Consultee Comment for planning application 6/2019/2228/LAWP

| Application Number | <input type="text" value="6/2019/2228/LAWP"/> |
| Location | <input type="text" value="Just House Coopers Lane Northaw Potters Bar EN6 4NJ"/> |
| Proposal | <input type="text" value="Certificate of lawfulness for an outbuilding"/> |

PROPOSED SIDE ELEVATION

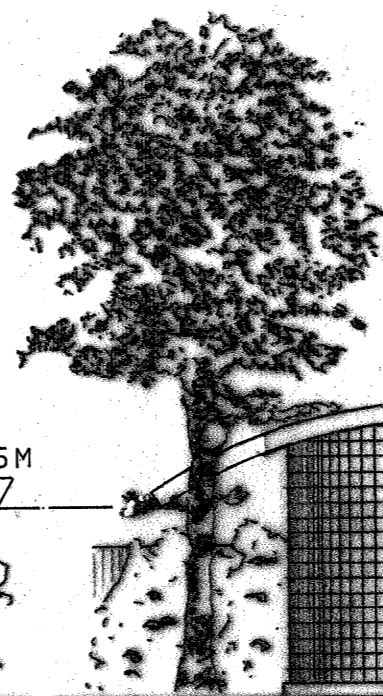
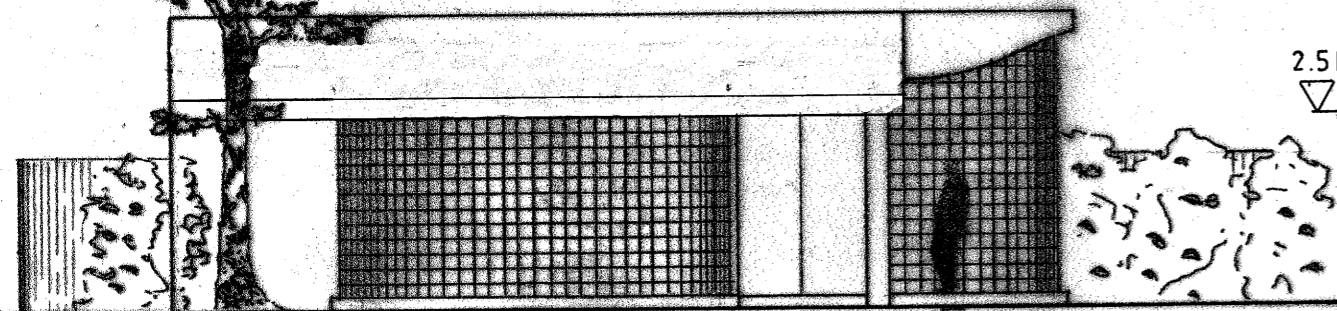
| Comments | <p>Thank you for consulting The Gardens Trust, of which HGT is a member. We are concerned (as indicated in our response to 6/2019/0737/LAWP) as to the adequacy of the screening. We note that the maximum height of the building is given as 4m and that the building is shown as 2m from the boundary on north and west sides. We would advise that sufficient planting is put in place which will provide adequate screening in all seasons. At present much of the tree cover is deciduous so that views across the historic landscape towards Well Road would be harmed during the winter months or if the tree cover is reduced in any way..</p> |
